WRITTEN REPRESENTATION

East Pye Solar - Planning Inspectorate Reference EN0110014

To: The Examining Authority, The Planning Inspectorate

Date: 11 September 2026

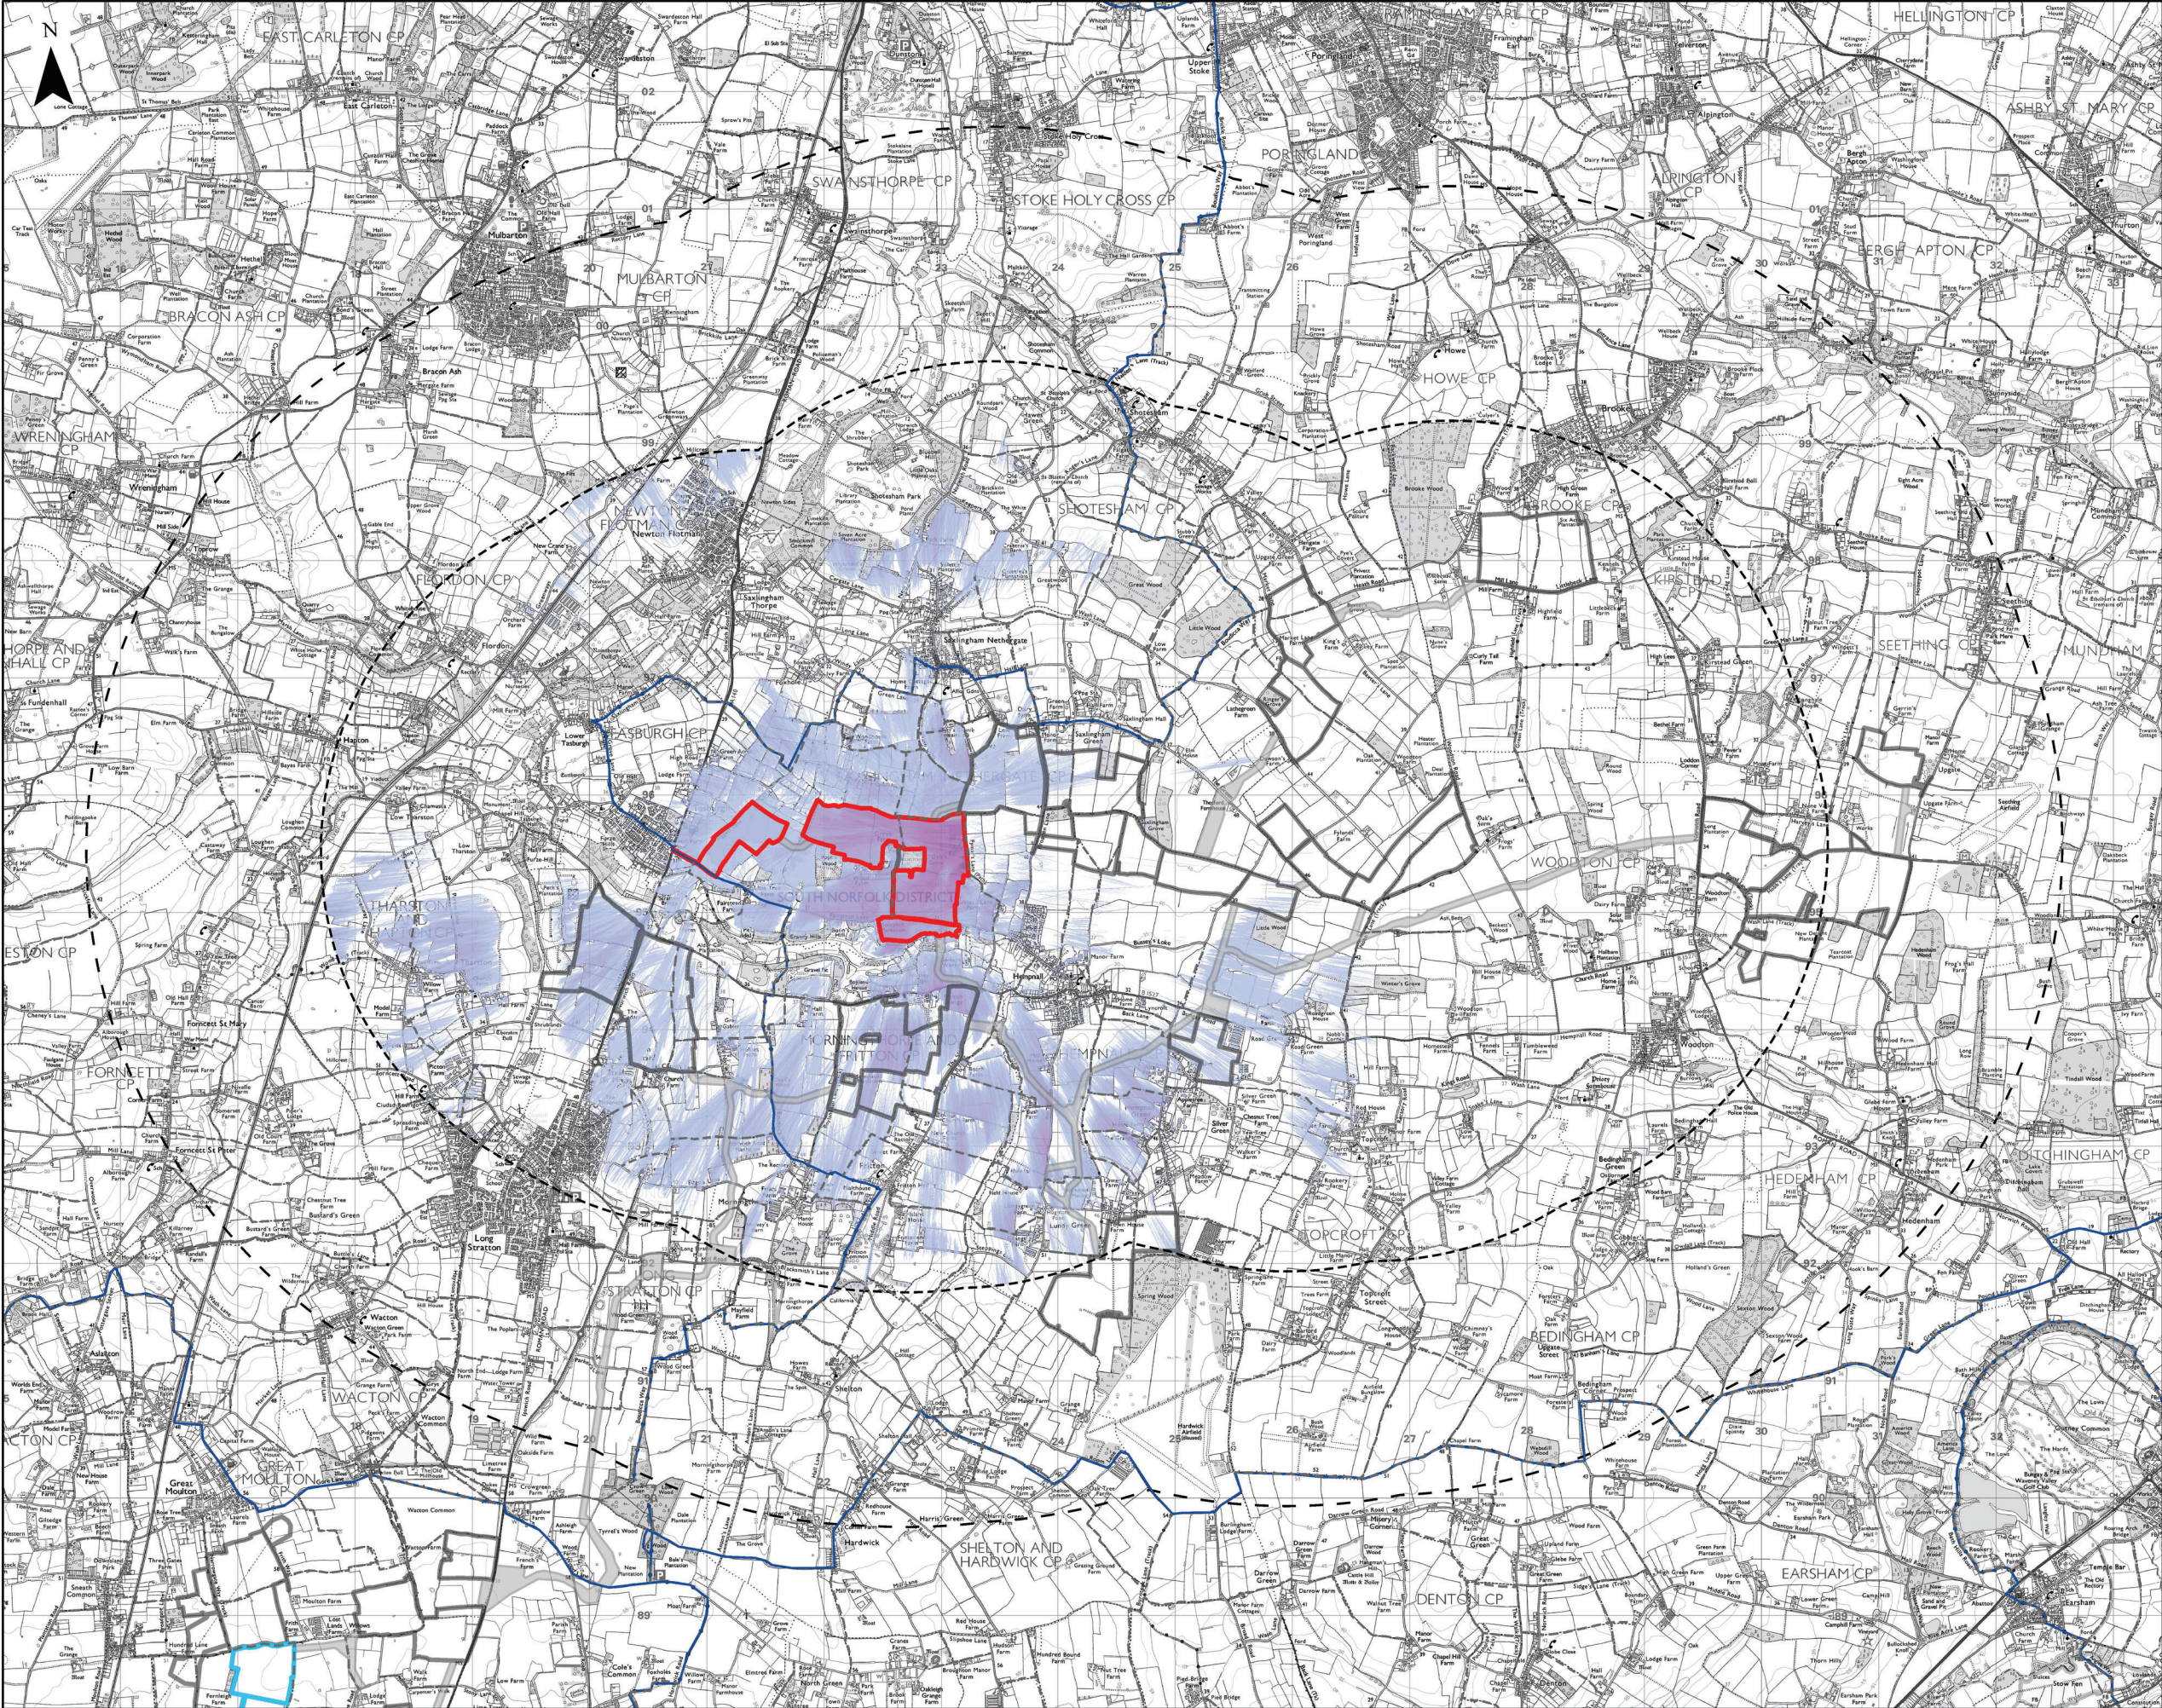
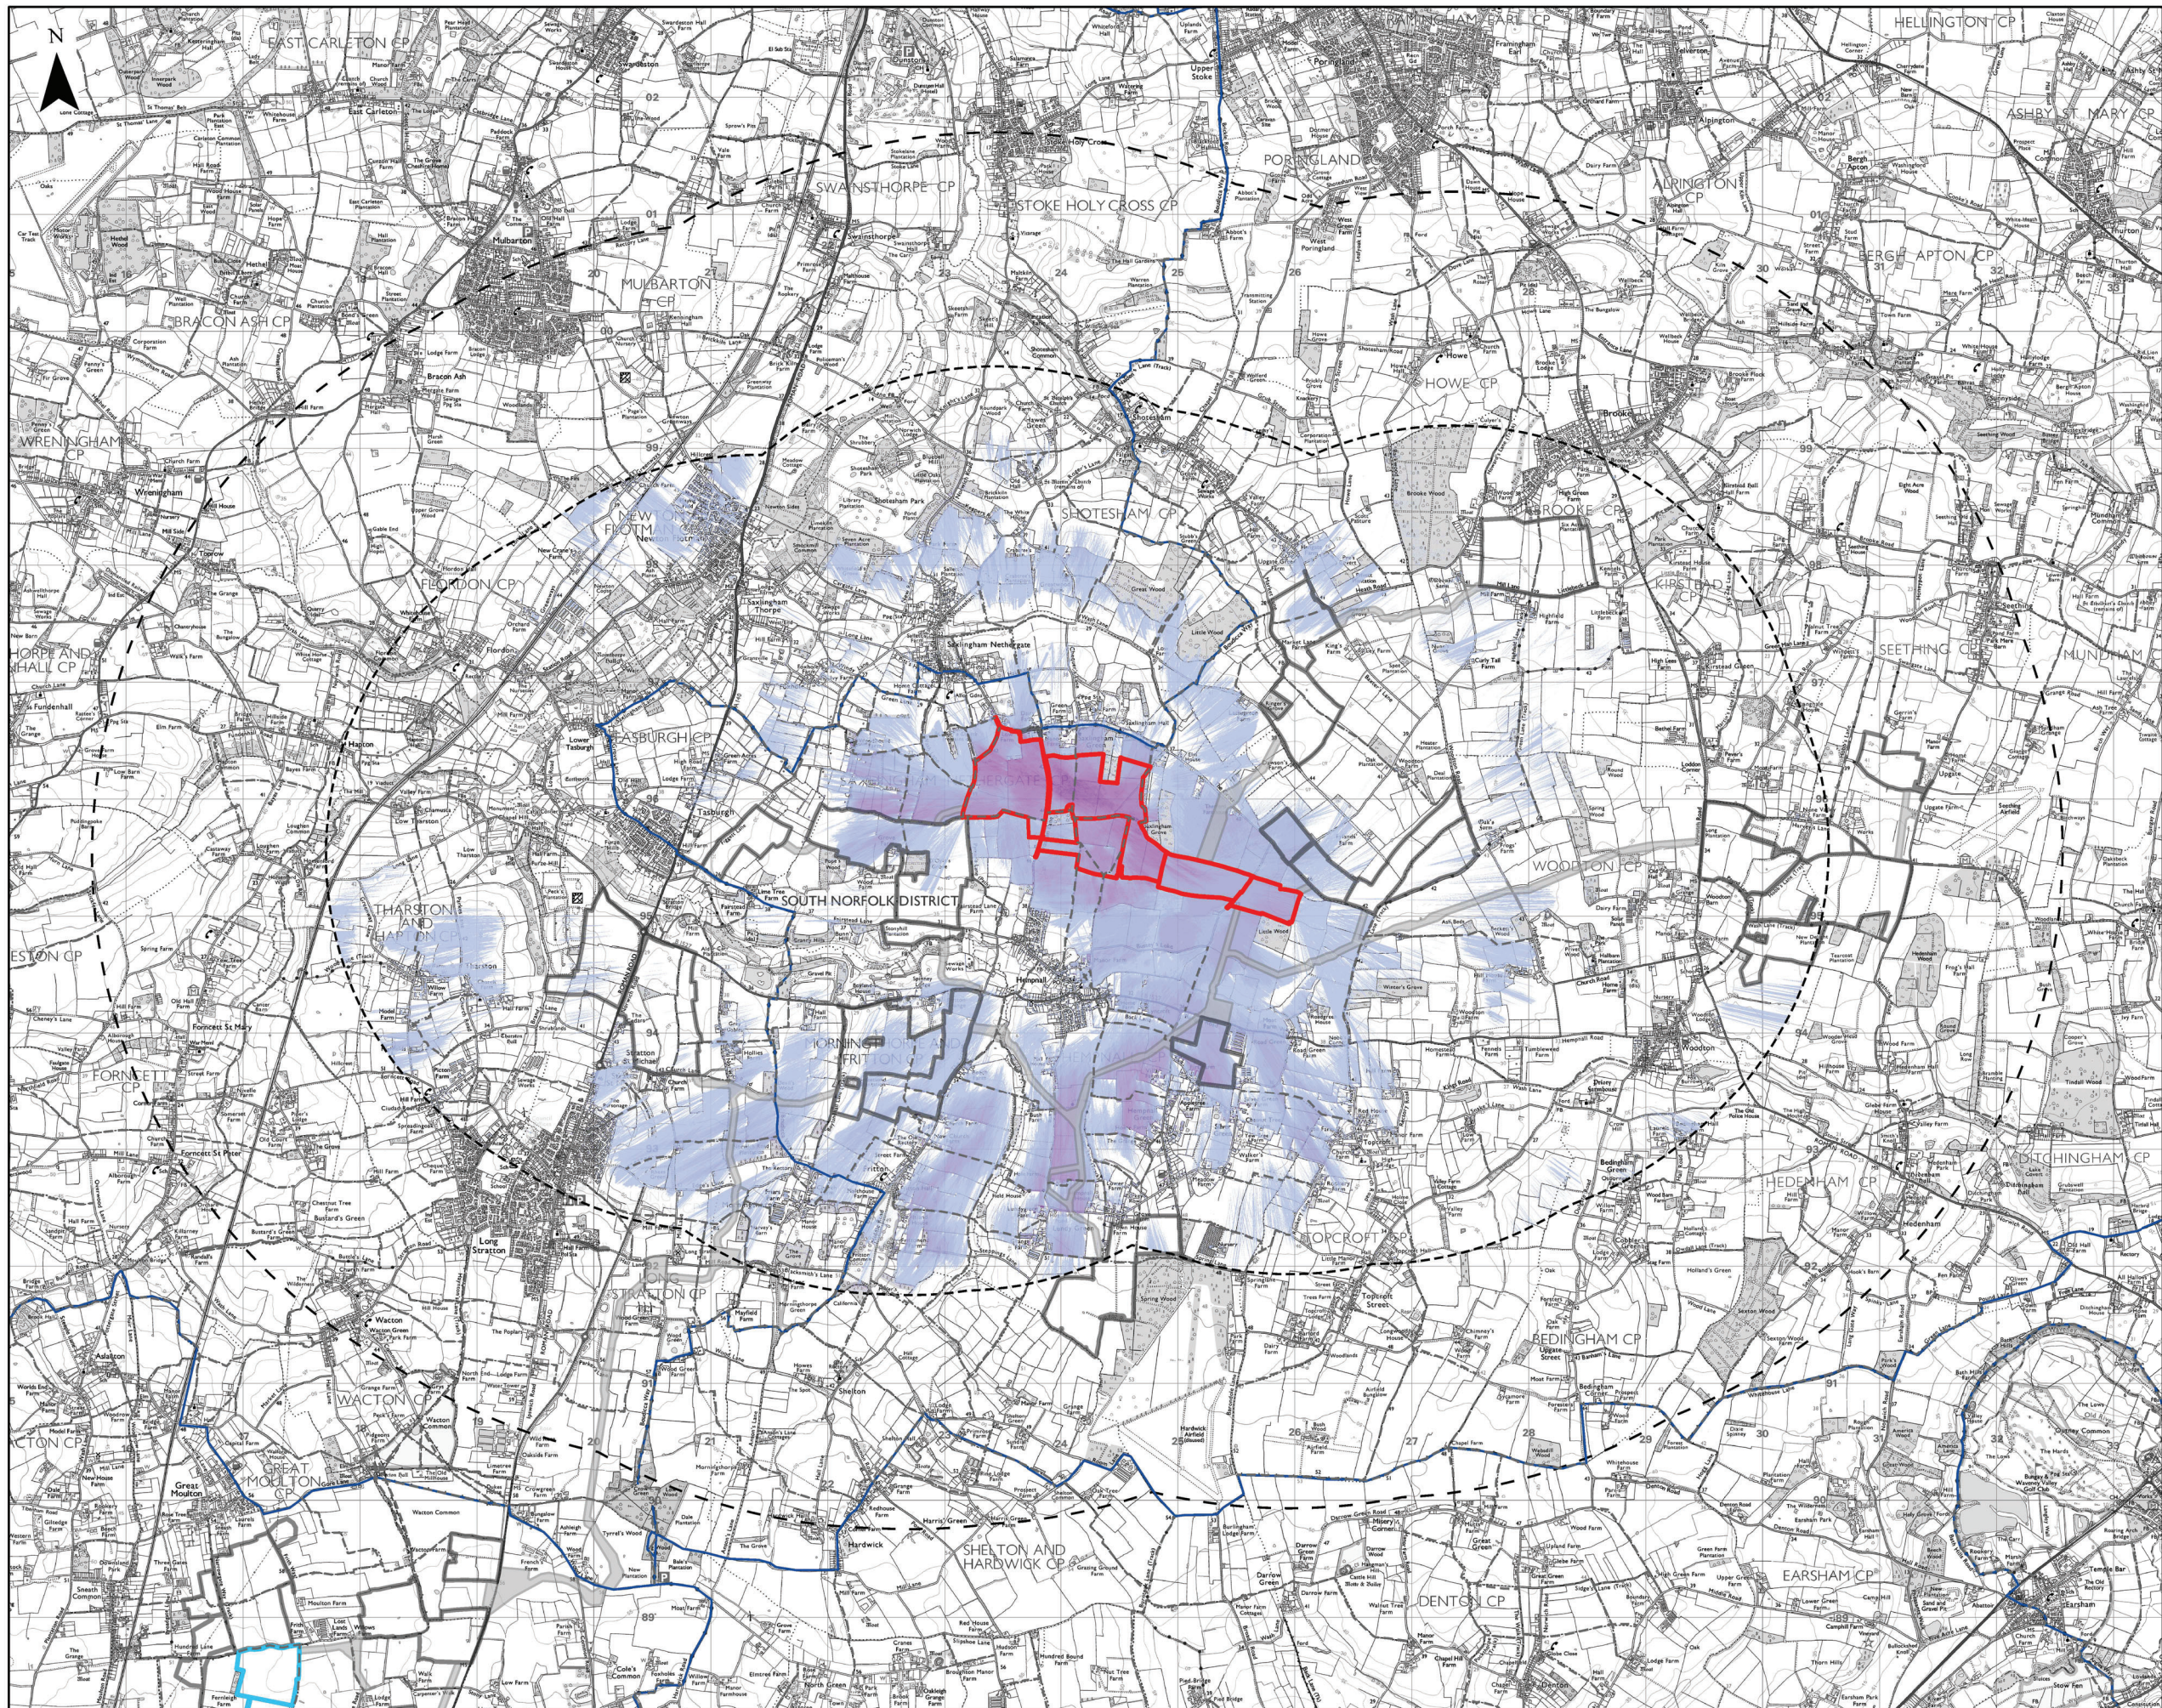
We therefore request that the Applicant be required to confirm whether **Church View Barn falls within the ZTV for Site 8 (Figure 7.5.4) and Site 7 (Figure 7.5.5)** and, if so, to explain why it has not been assessed as a named or representative residential receptor.
